Our ref: DOC19/950259
Senders ref: SSD-8699

Subject: EES comments on Response to Submissions for redevelopment of Greenwich Hospital (concept) – SSD-8699 – 97-115 River Road, Greenwich

Subject: EES comments on the Response to Submissions for redevelopment of Greenwich Hospital (concept) – SSD-8699 – 97-115 River Road, Greenwich

DRAWING TITLE: EXISTING TREES		DATE: AUGUST 2019		DRAWN: EC		PROJ ARCH: BF		SCALE: 1: 500 @ A1	
				PROJ: 1213		DRAWING: S.10		REVISION: P5

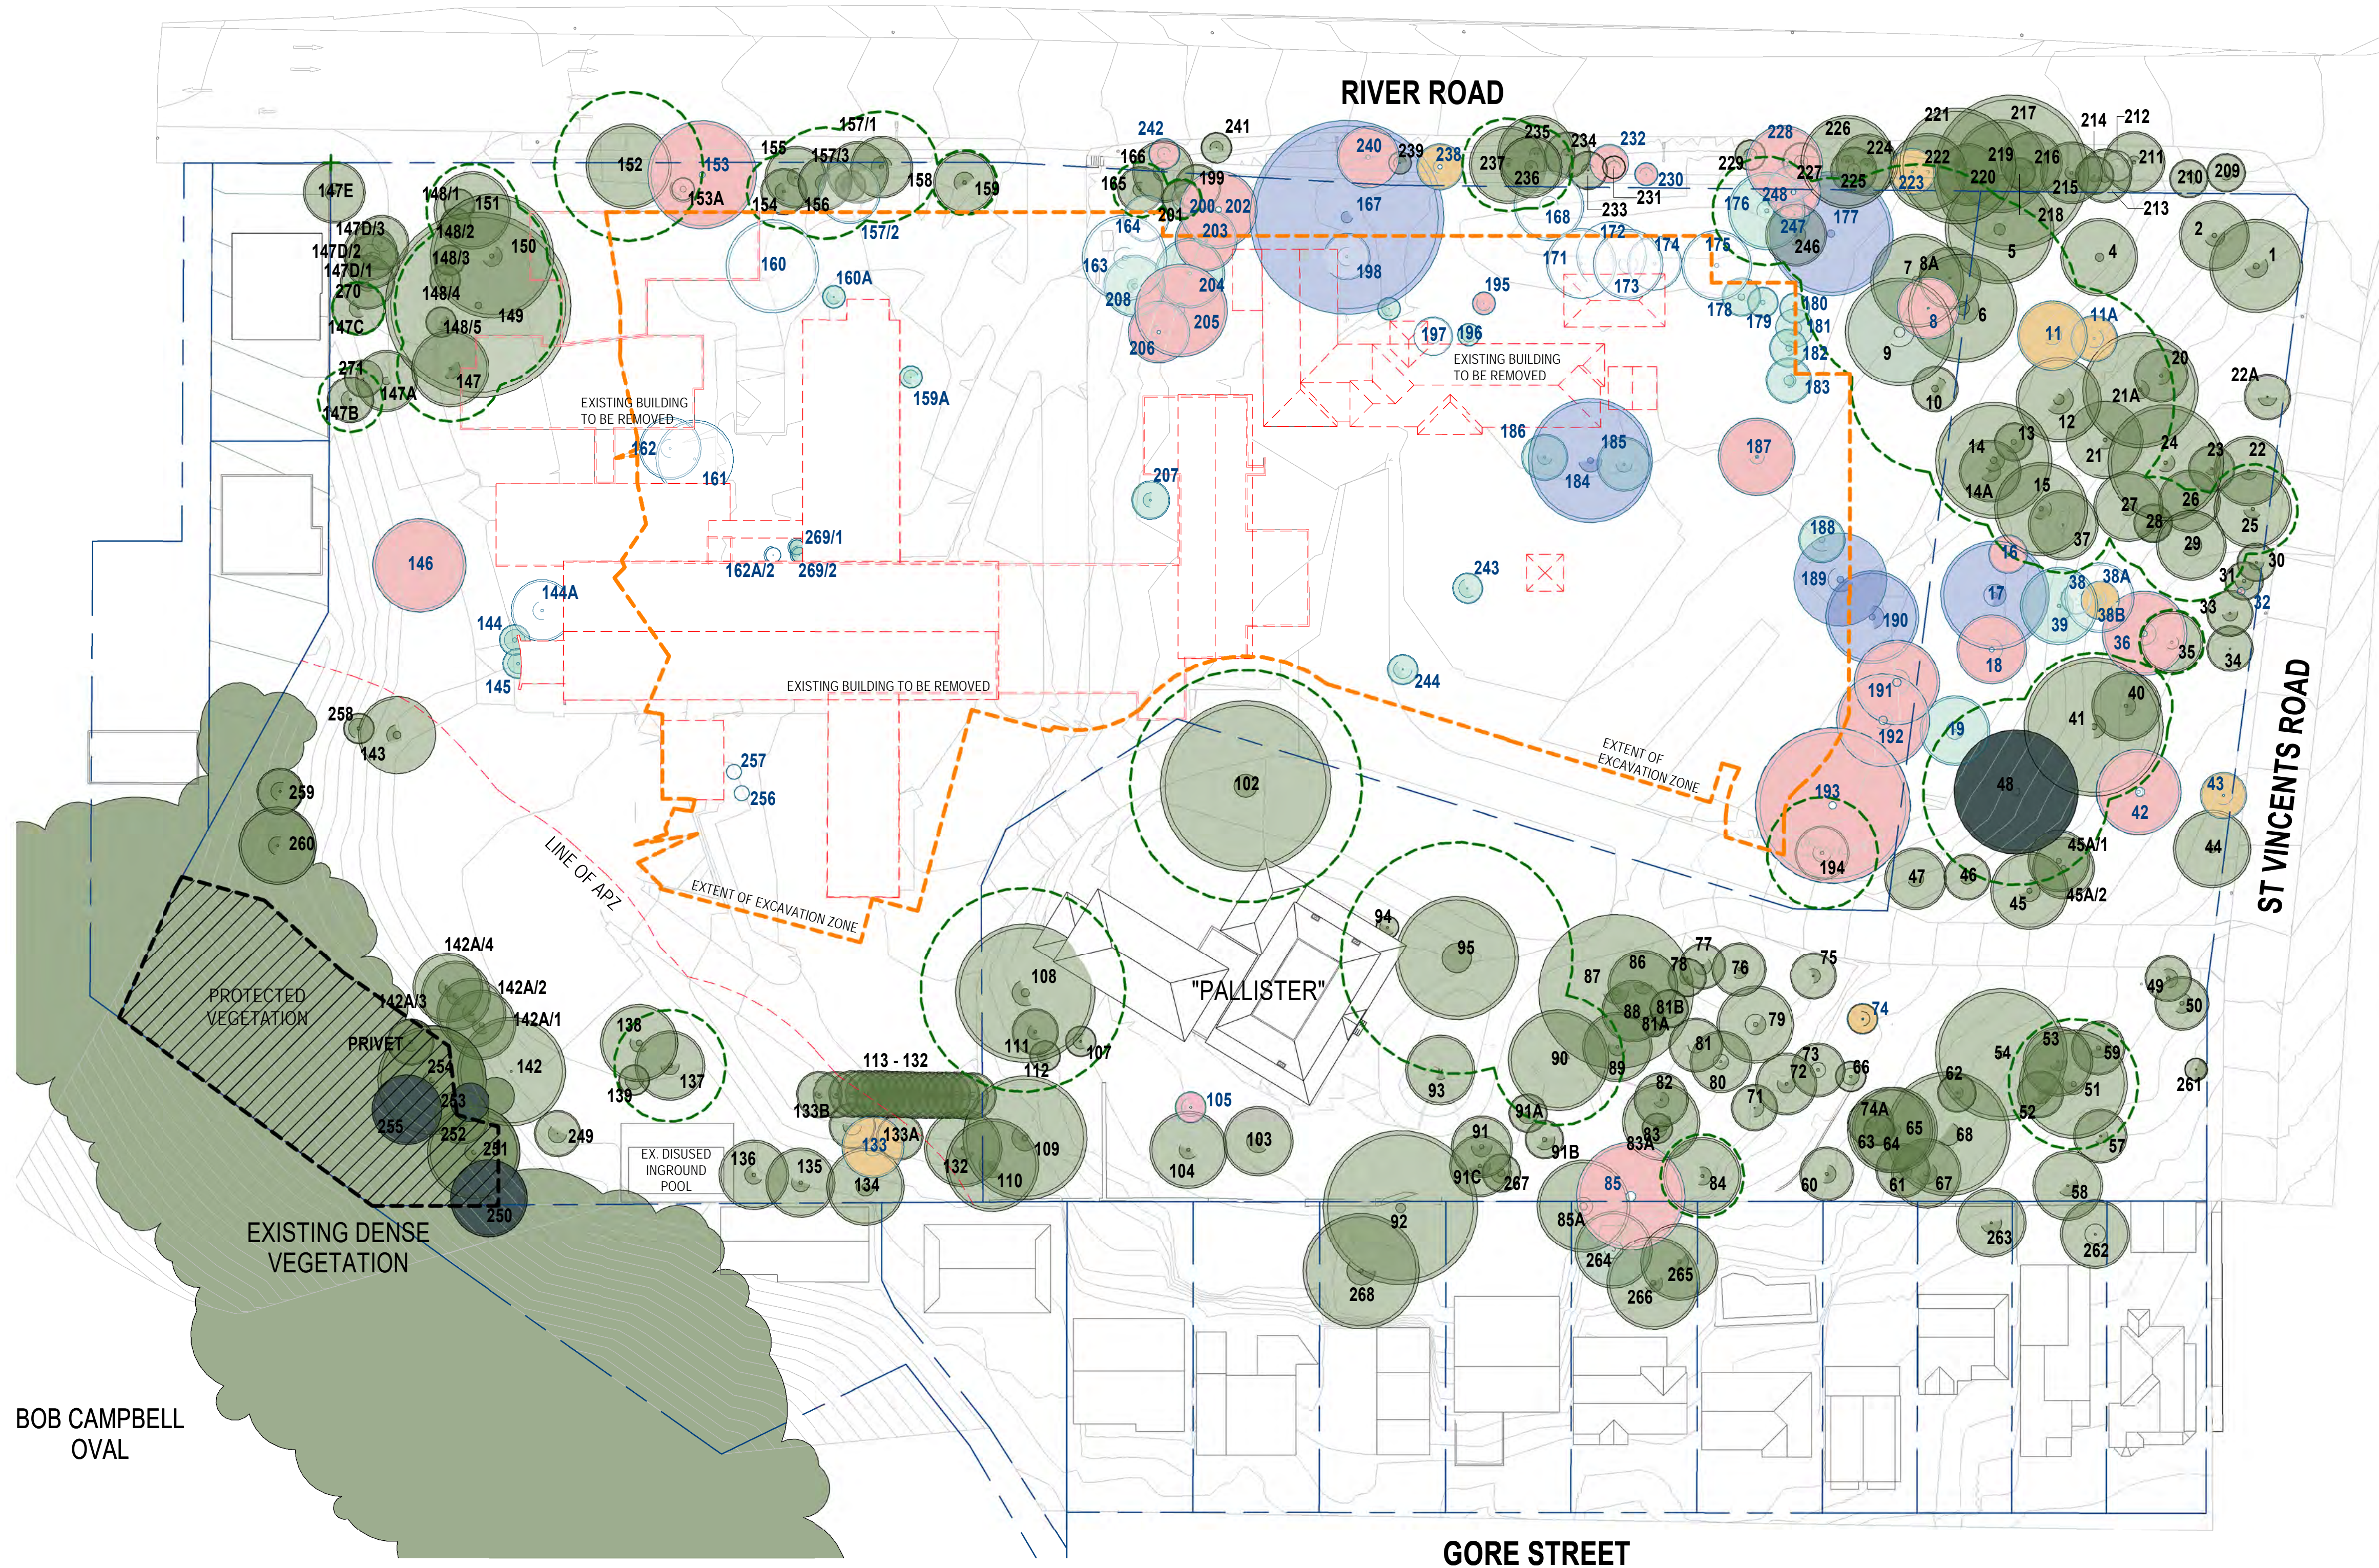
EES notes the AIA proposes to retain invasive exotic trees at the site including:

- 6 x Camphor Laurel (*Cinnamomum camphora*) – (see Table 1, tree numbers 1, 60, 61, 67, 68, 252)
- 2 x Chinese Tallowwood (*Triadica sebifera*) - (see Table 1, tree numbers 158, 201).

It is unclear why the AIA proposes to retain some invasive tree species and it also proposes to remove the same species, for example, six Camphor Laurels are proposed to be removed (see Table 1, tree numbers 8, 32, 146, 191, 192, 248 in AIA) and six are proposed to be retained.

The AIA also proposes to retain other exotic trees such as Hackberry (*Celtis*) (see table 1, tree numbers 112, 147B) and Hawthorn (*Rhaphiolepis* sp.) (see table 1, tree number 239).

The proponent needs to clarify if Hackberry (*Celtis*.) is *Celtis sinensis* and if Hawthorn (*Rhaphiolepis* sp.) is Indian Hawthorn (*Rhaphiolepis Indica*) as the BDAR records *Celtis sinensis* and Indian Hawthorn as occurring by plot (see Table 30, Appendix B, pages 64 and 66).

The spread of seed from these invasive trees from the site is a concern, particularly as the site adjoins Gore Hill Reserve to the south west, which contains a densely vegetated area of bushland and includes the riparian corridor of Gore Creek. It is recommended:

- invasive exotic species are removed from the site and replaced by local native provenance species and a condition of consent is included to this effect. As recommended in Table 21 of the BDAR, any resident fauna should be relocated in a sensitive manner under the supervision of a qualified ecologist/licensed wildlife handler
- the proponent provides the Department with a revised total number of trees that are proposed to be removed from the site and clarifies if the proposed planting on the site still exceeds tree removal.

1. All mitigation measures listed in Table 21 of the BDAR must be implemented.
2. Invasive exotic species are to be removed from the site and replaced by local native provenance species.

3. Trees removed by the development shall be replaced by a diversity of local native provenance species at a ratio greater than 1:1.
4. Enough area/space is provided on site to allow the trees to grow to maturity.
